MEMORANDUM

Subject: Application ID: 2014-038

Date: 7/7/2014

Comments Submitted by: Marge Schmuckal/Zoning on 7/3/2014

TREE REMOVAL SUMMARY
(WITHIN 250' SHORELAND SETBACK)

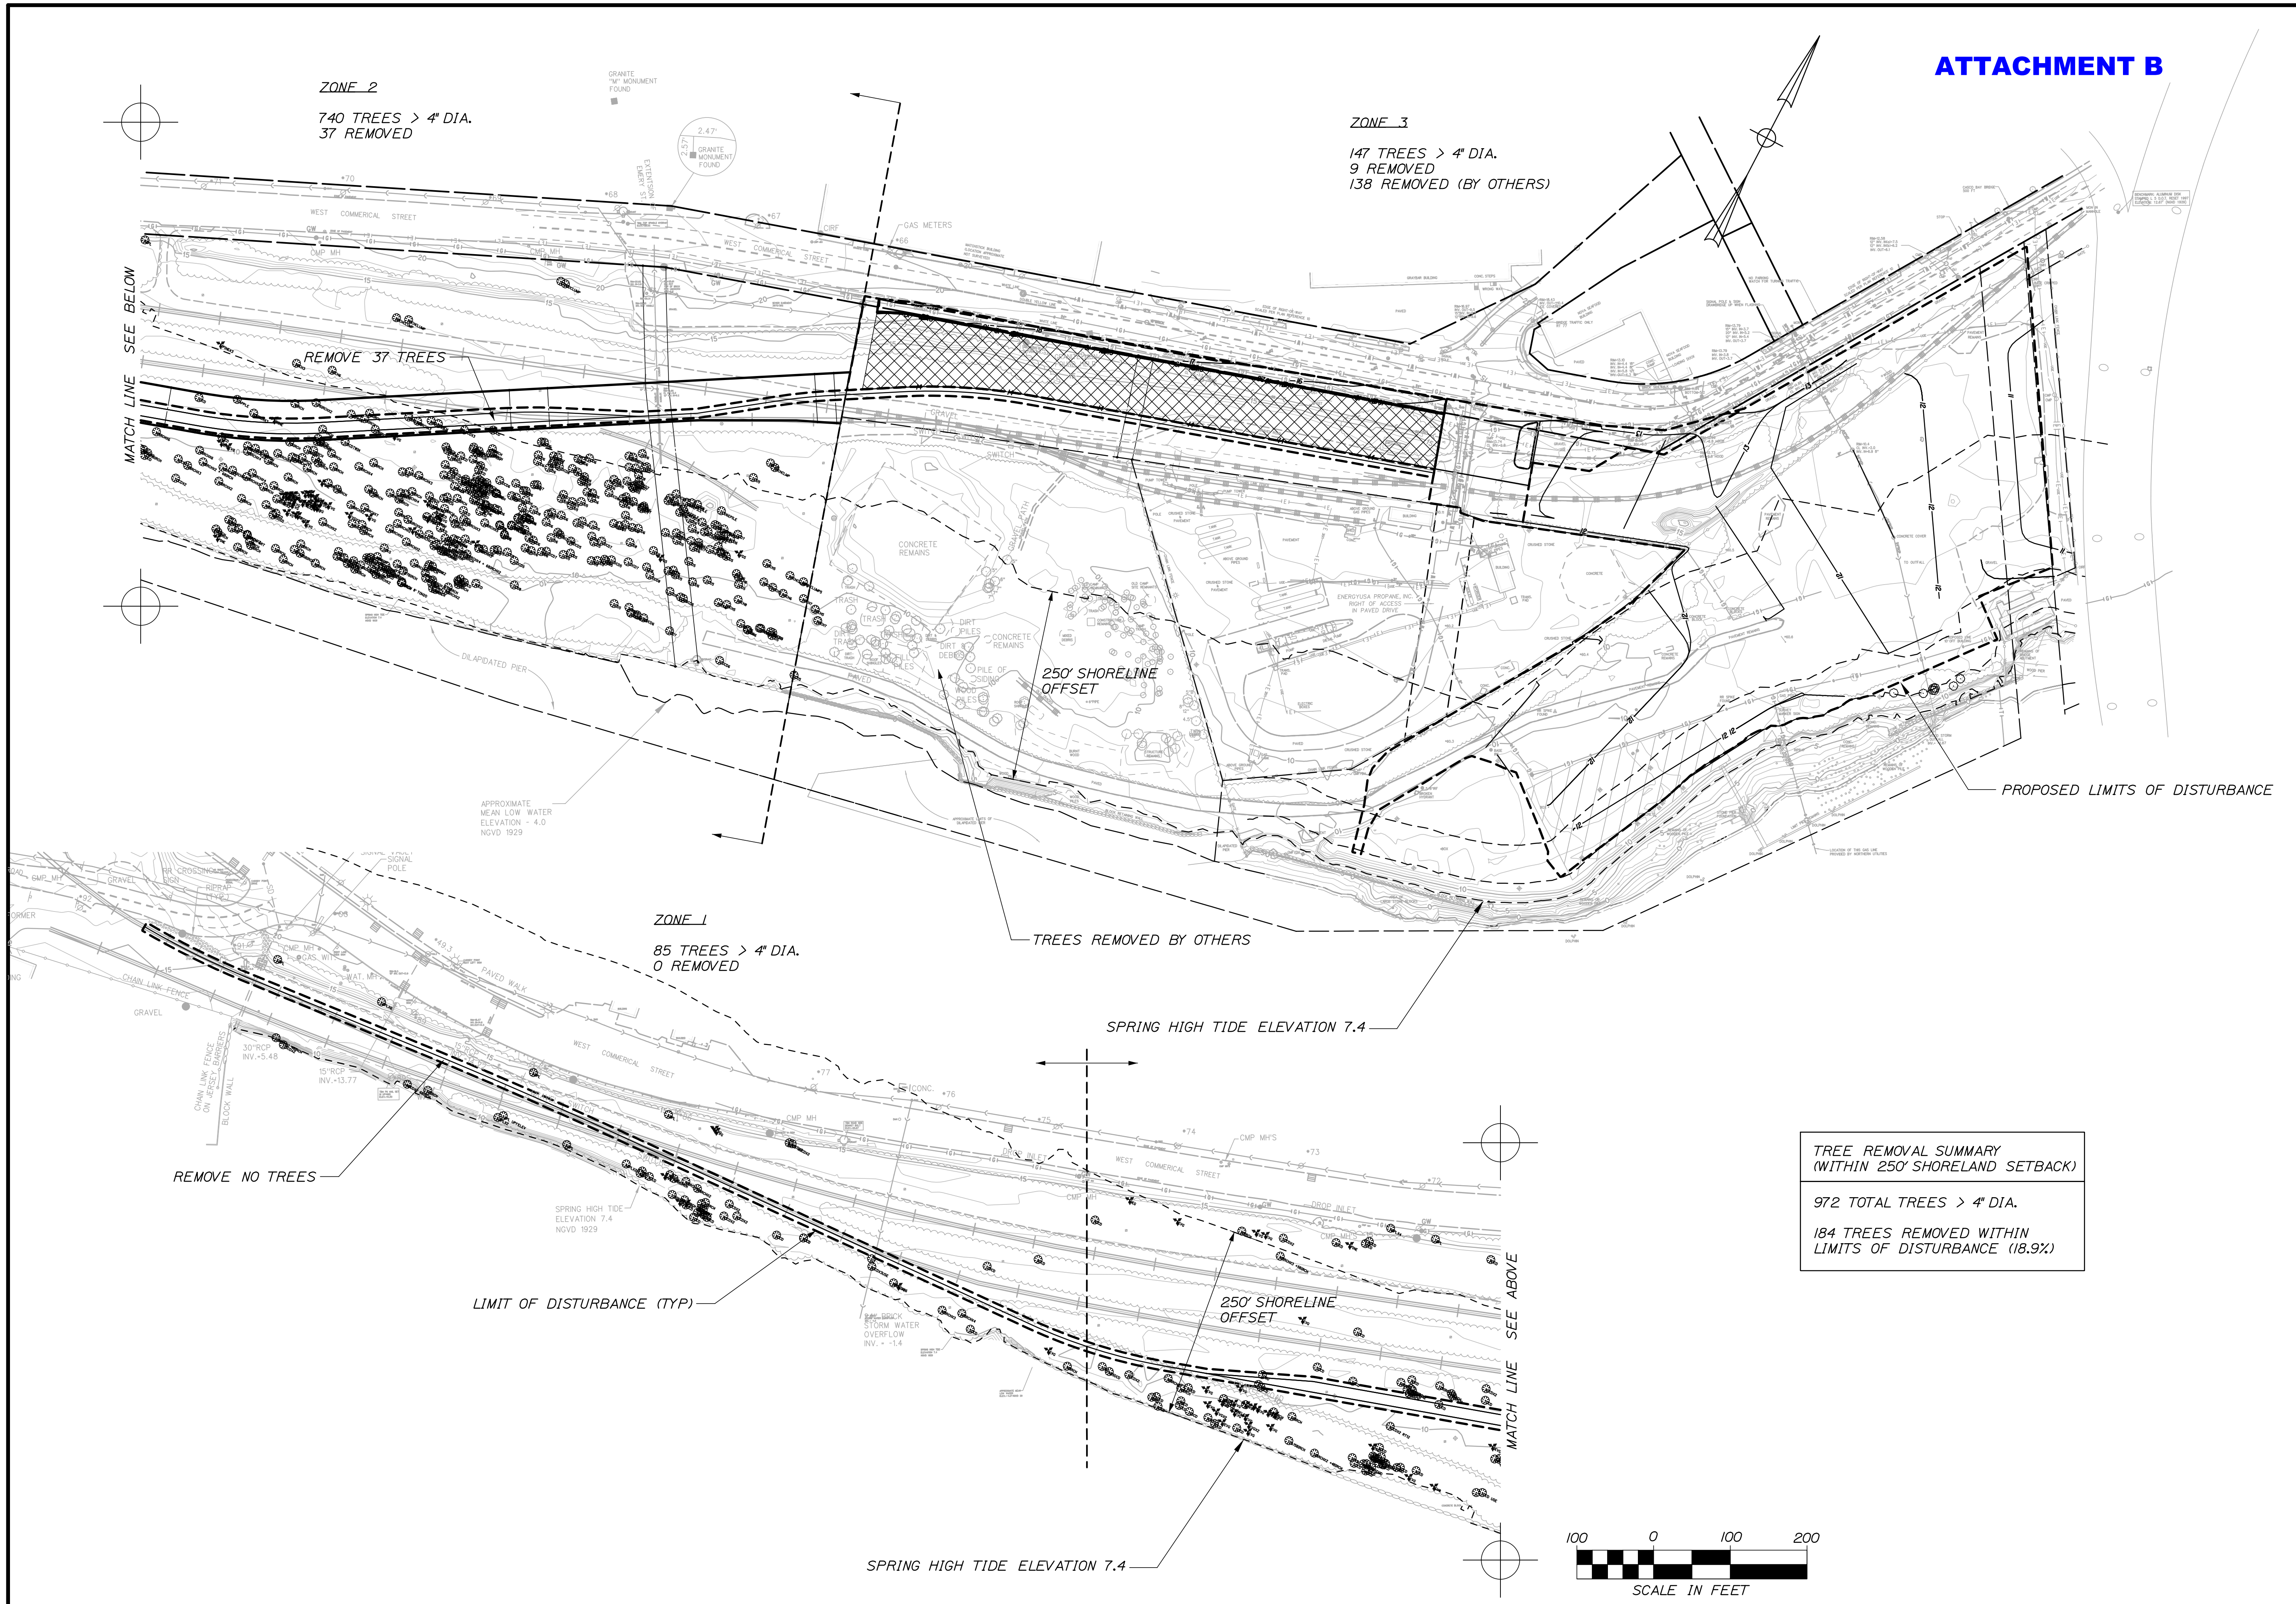
I have reviewed the information recently submitted in response to my last comments. They do address my concerns. I have learned since then that working waterfront land is now exempt from meeting the clearing of vegetaion under the shoreland area. Under Sec. 2.38 MRSA subsection 439-A, sub 6-A. Therefore the WPDZ standards for this project are being met.
